Please ask for: Ms Iqraa Malik
Email: iqraa.malik@terraquest.co.uk
Telephone: 01212341390
Our Ref: BN/113/21/HH
Your Ref:
Date: 23rd August 2021

Application for Planning Permission for Works or Extension to a Dwelling

Development: Erection of single storey side extension and loft conversion with 1 x rear dormer following the demolition of existing single storey front and side extensions
Location: 26 Gospond Road Barnham PO22 0EU

BLOCK PLAN 1:200

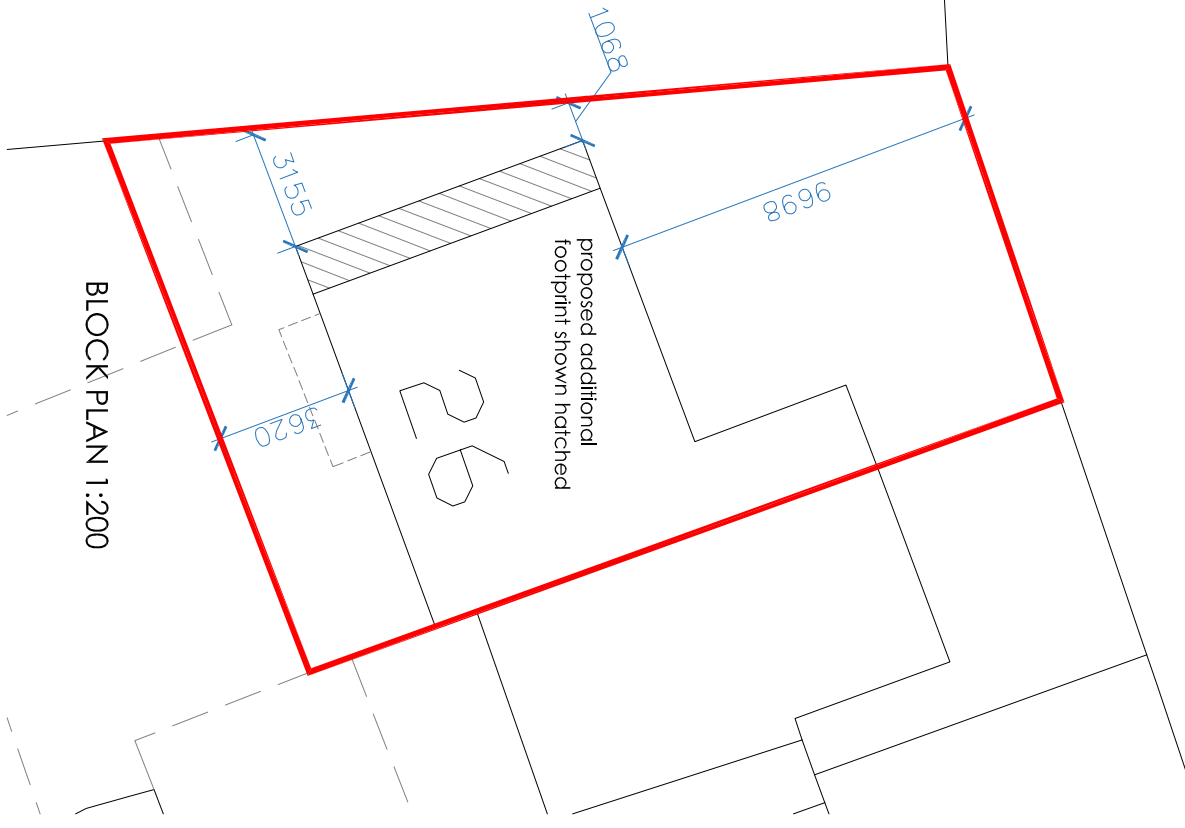
Block Plan

You are required to have dimensions from the proposed extension(s) to all site boundaries. Please amend.
